DECISION DELEGATED TO HEAD OF PLANNING

Application No: H01-0966-21 **Applicant:** AC Building Peterborough Ltd.

Proposal: Demolition of existing dwelling and workshop, erection of up to five detached dwellings including hard standing & access from Backgate - approved under H01-1047-20. Modification of Condition 1 to allow amendments to previously approved plans (change of design of plot numbers 4 and 5).

Location: 22 Backgate Cowbit Spalding

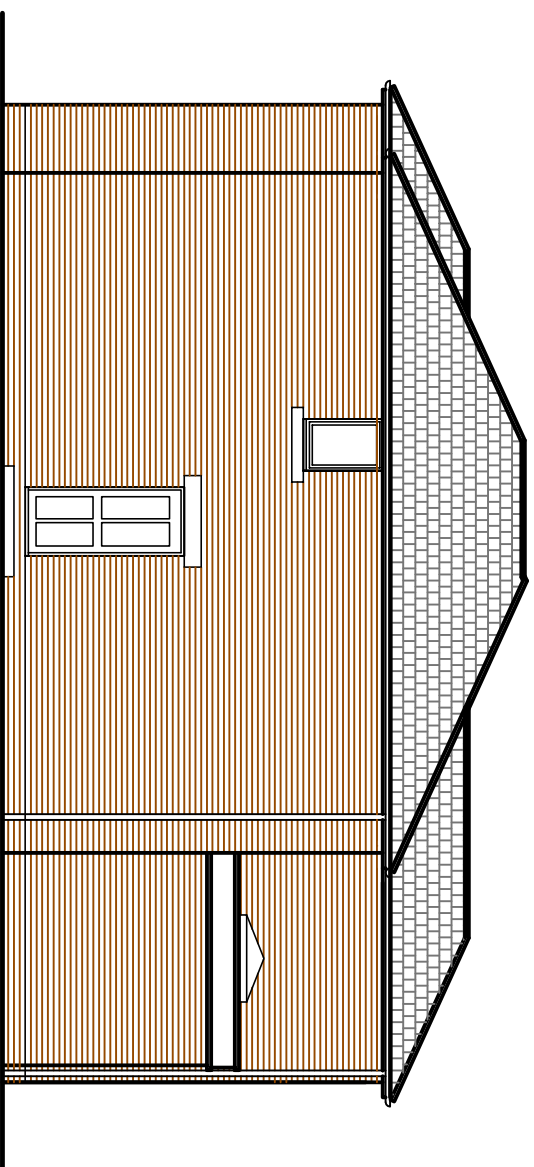
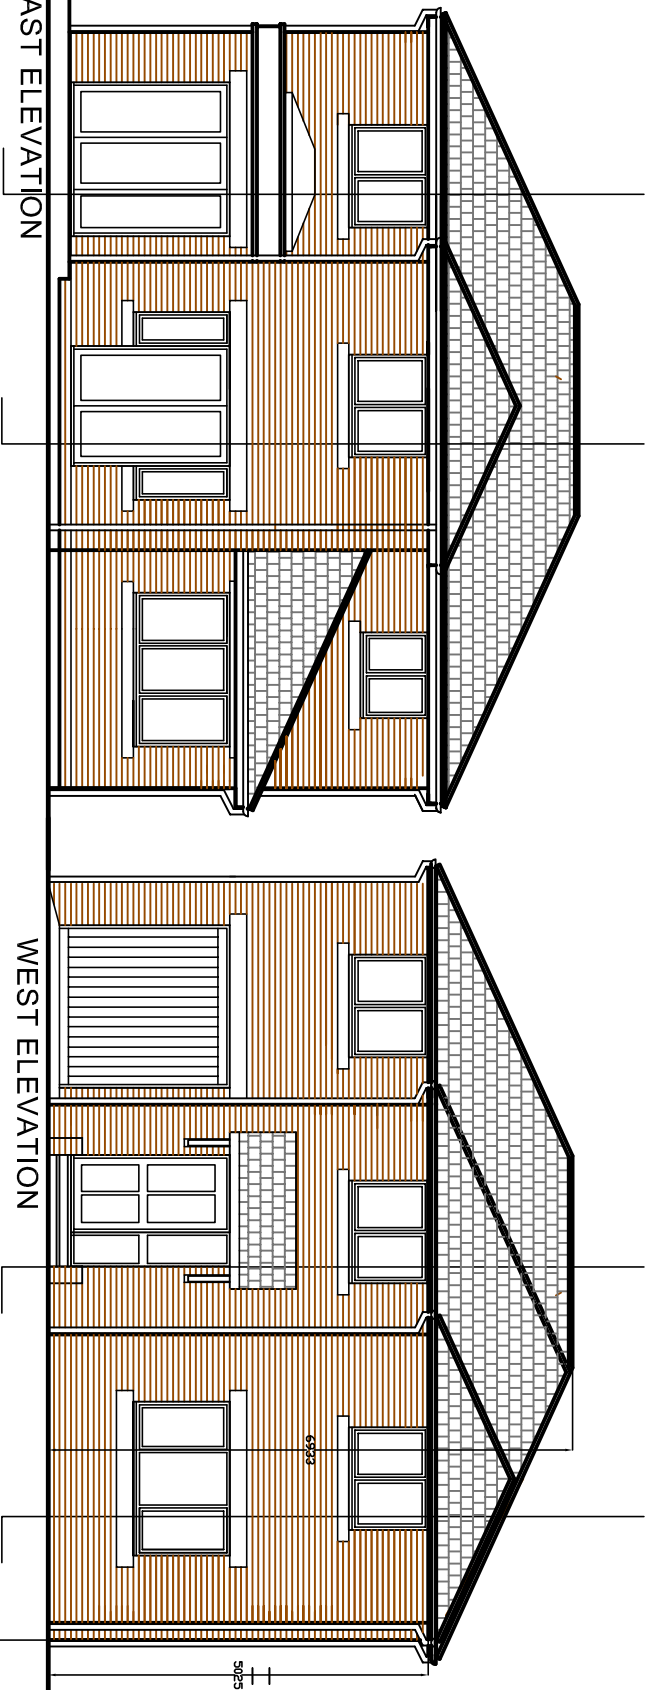
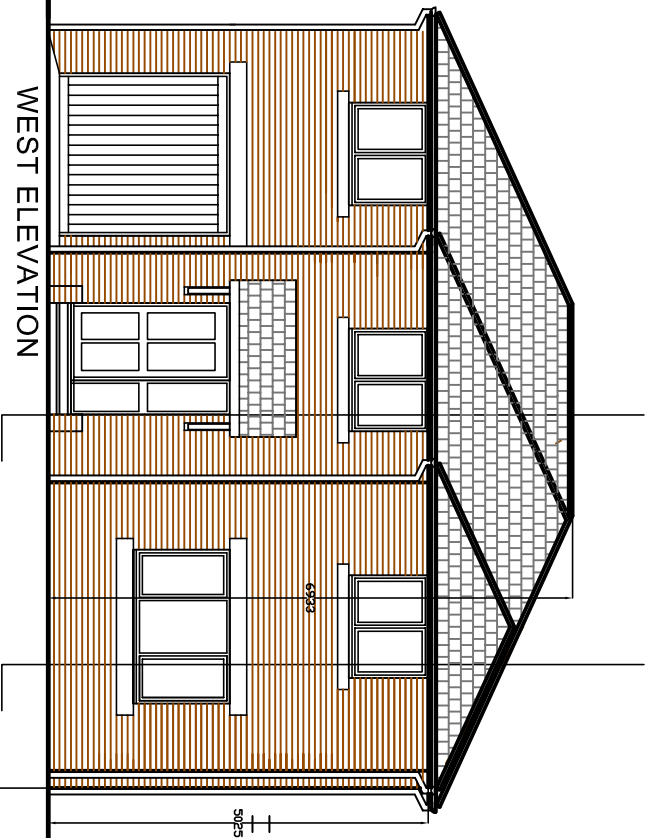
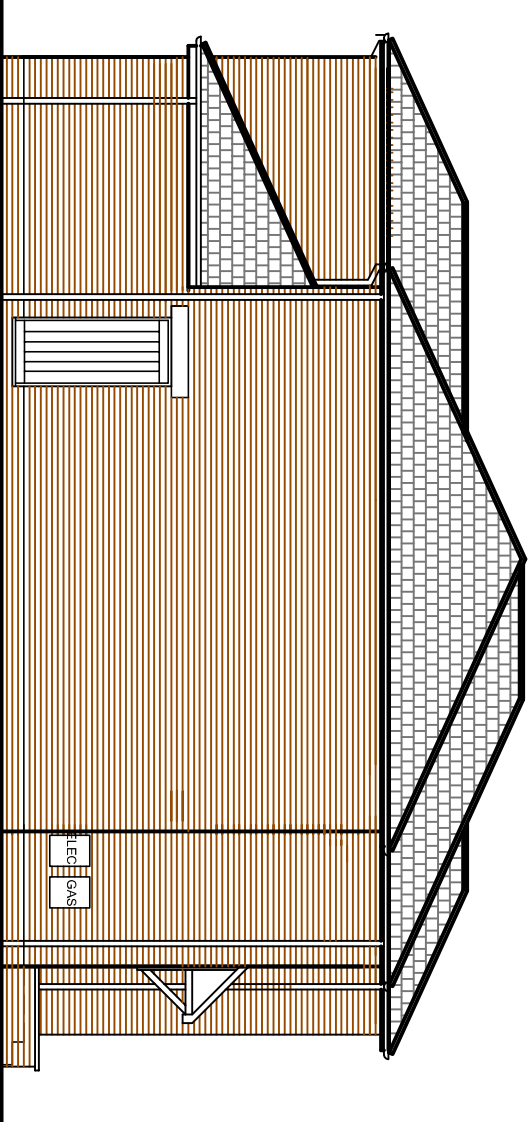
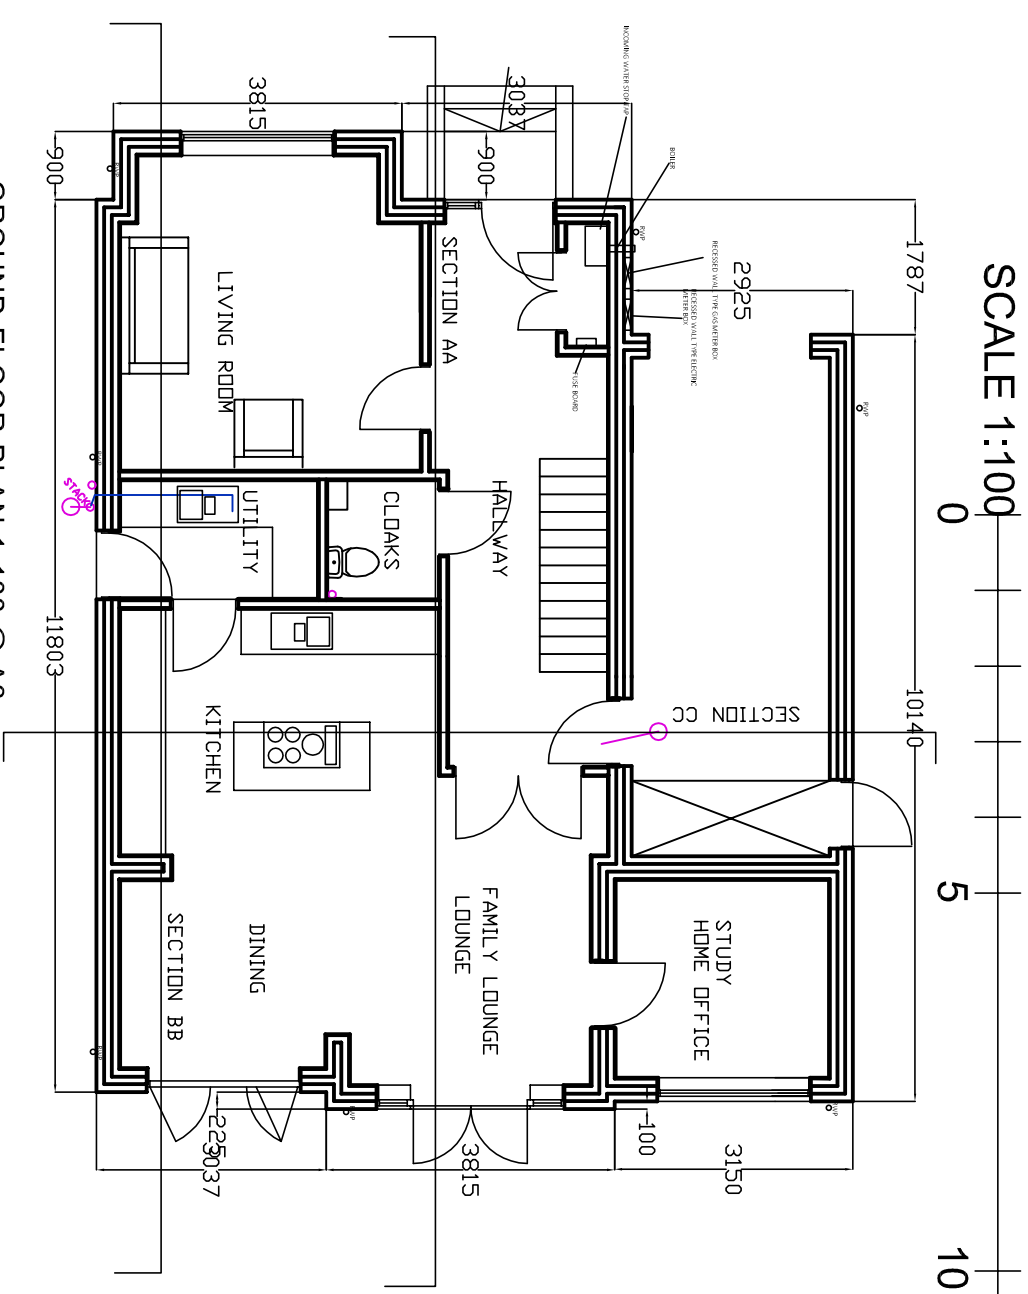
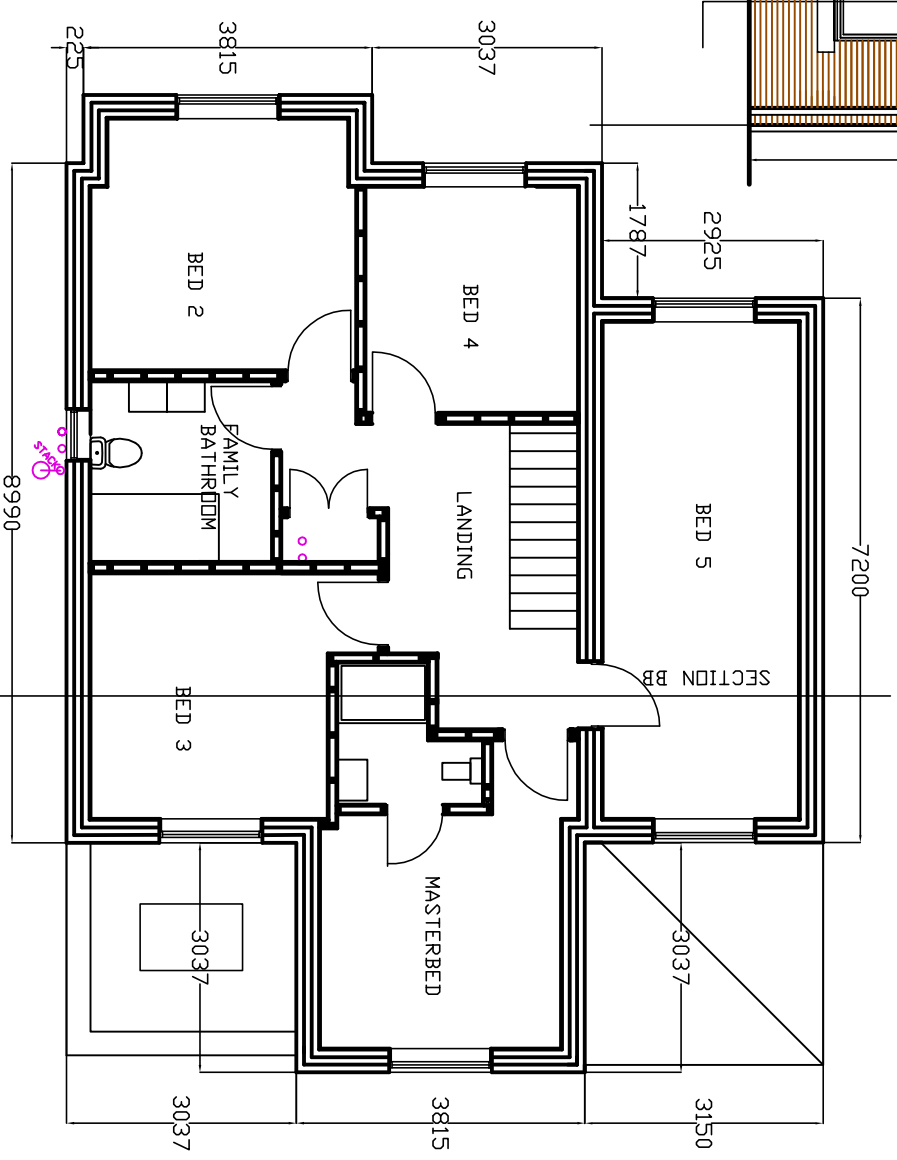
- Additional bedroom over garage for Plots 4 and 5
- Gable roof to Plot 5 changed to hipped roof

The proposed modifications are for an additional bedroom over the garage for Plots 4 and 5, with the gable roof to Plot 5 being changed to hipped roof. As the footprint would not be enlarged and there would be a cohesive roof arrangement, these alterations would not have an adverse impact on the character or visual appearance of the individual dwellings, overall scheme or wider area.

Plot 4 is sited in between dwellings on site and therefore the proposed alteration to this plot will not have an impact on existing neighbouring residents.

Plots 4 and 5 would be increased from 4-bed dwellings to 5-bed.

Appendix 6 of the Local Plan sets out minimum parking standards, including for new residential development. 3 parking spaces within the curtilage should be provided for dwellings with 4 or more bedrooms. Between the garaging and the driveway space provided, the proposal still complies with this requirement.

Scale: AS NOTED @ A3	Date: 26/08/20
Drawing Title: PROPOSED DWELLING PLOT 5	
Drawing No: 381SK01-6	Revision: D

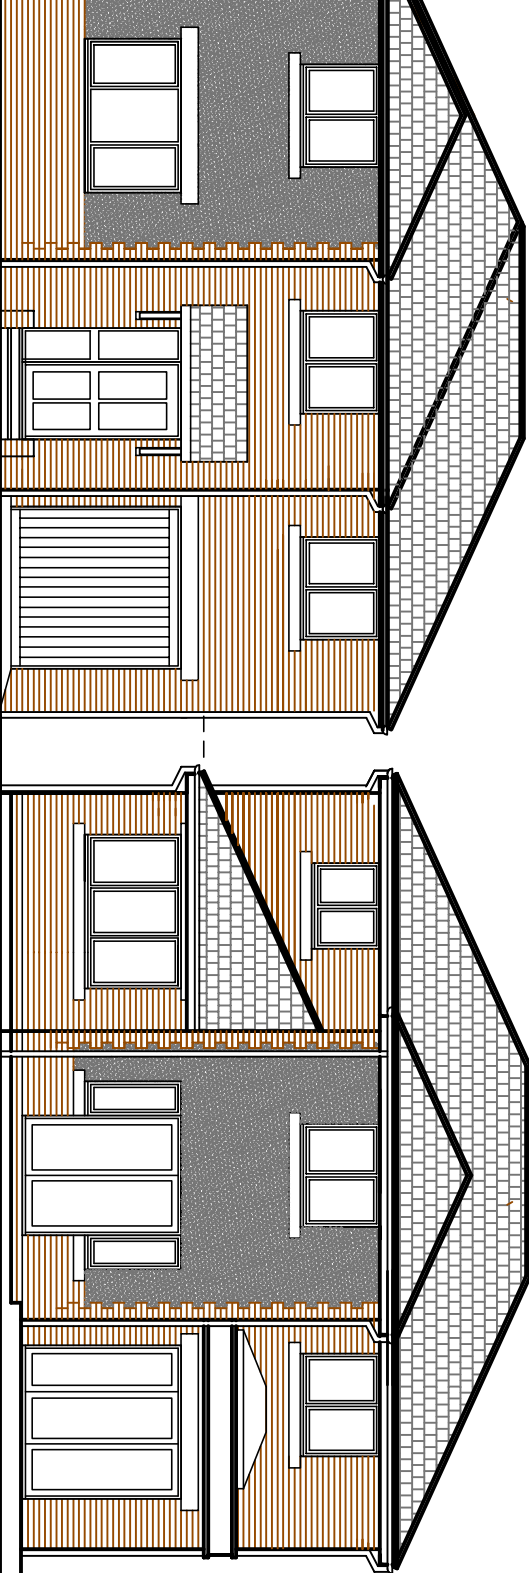
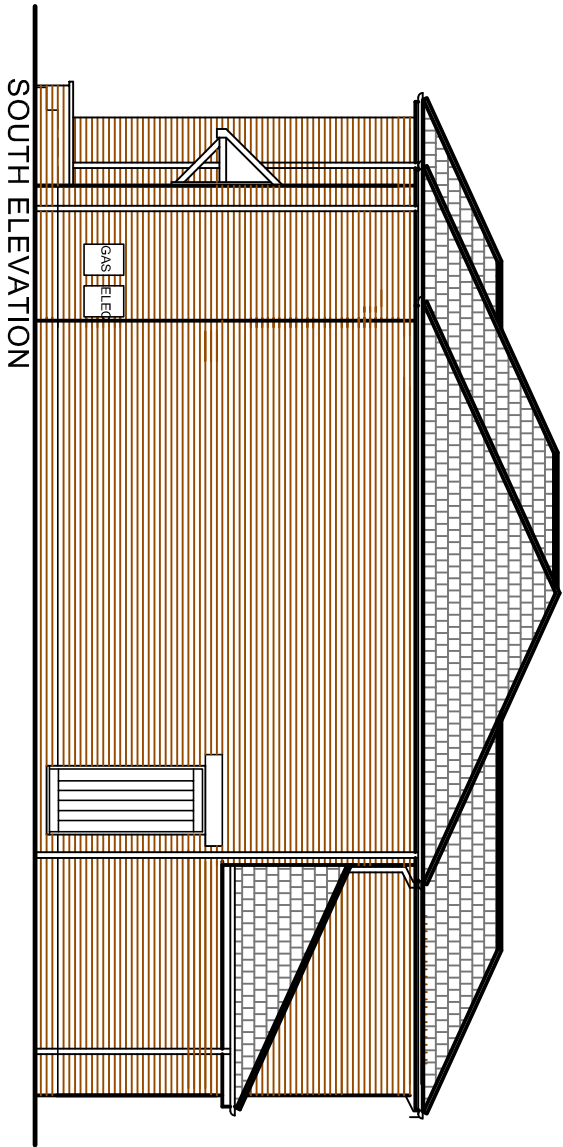
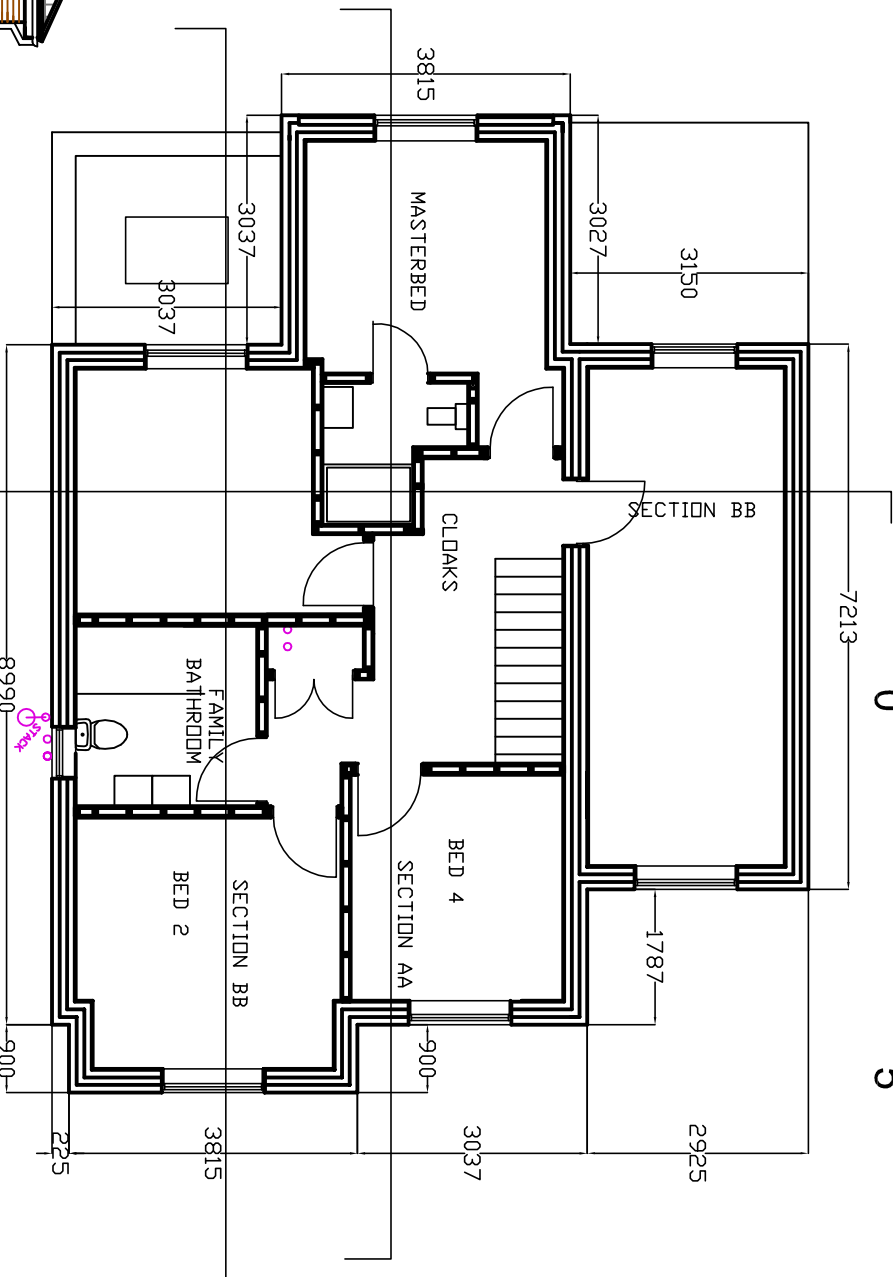
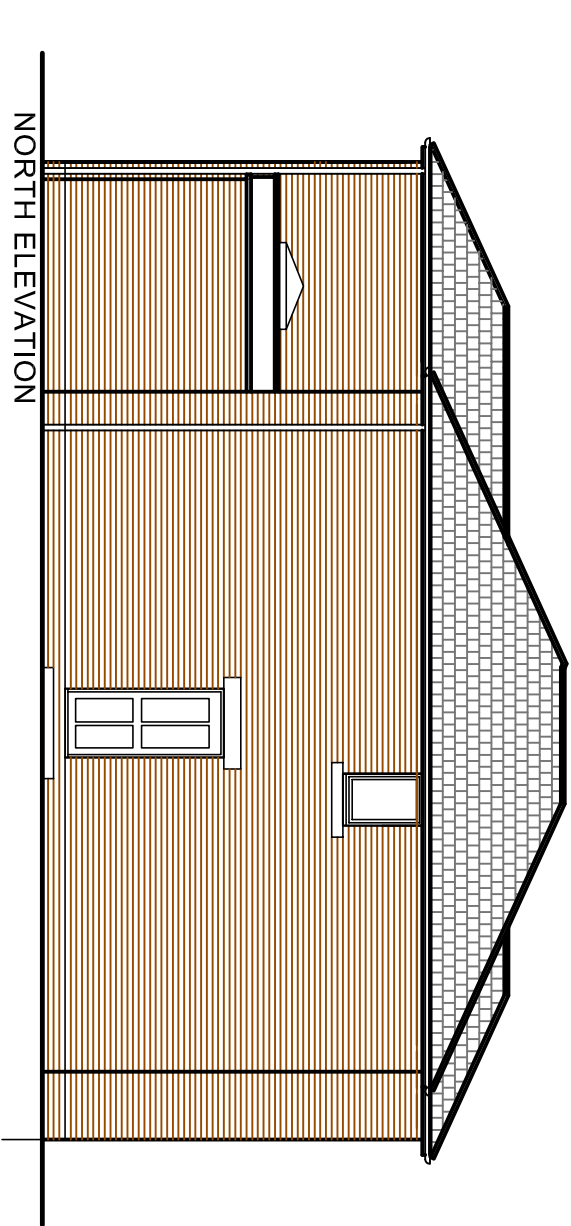
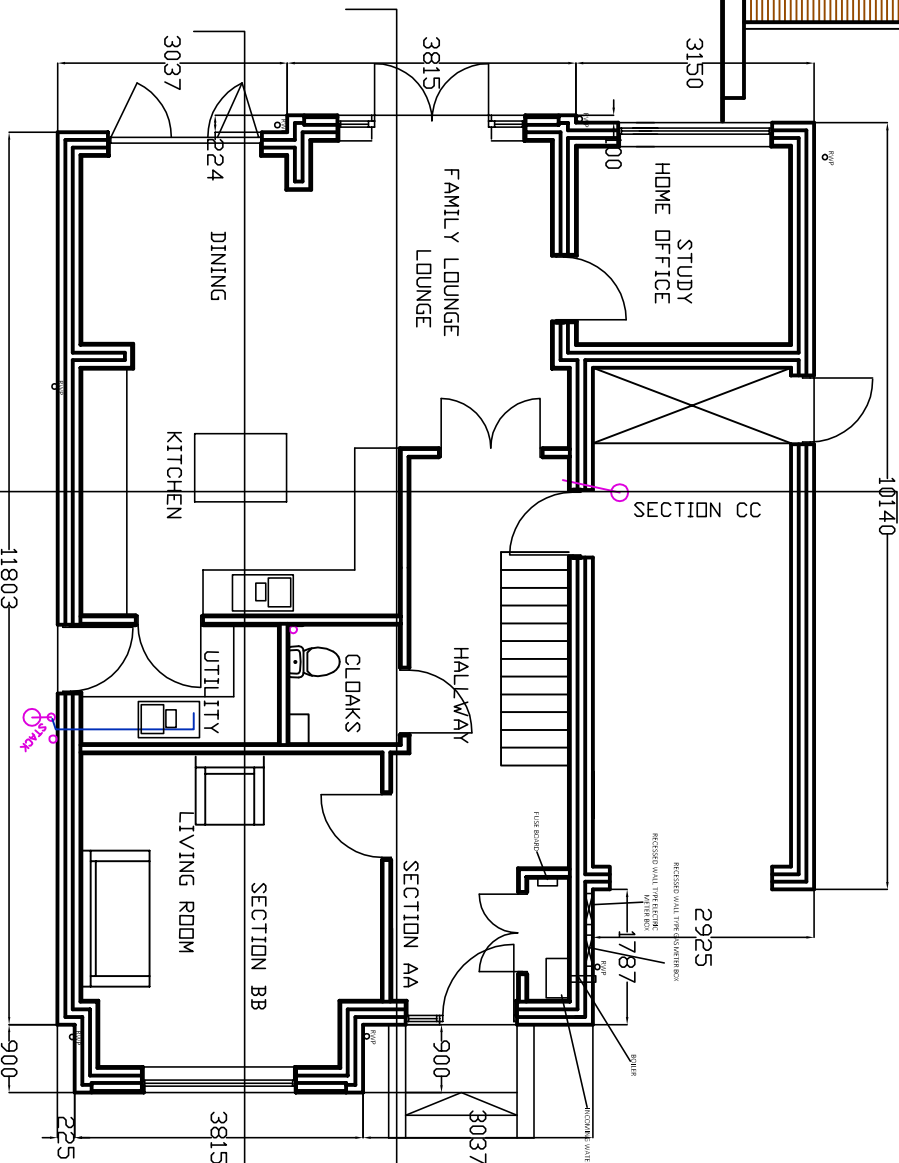
There is a bungalow to the south of Plot 5 but there would be no side facing windows introduced at first floor. The two storey facing wall would be brought closer to the neighbouring dwelling to approx. 12m away from the facing elevation. This is still an acceptable separation distance.
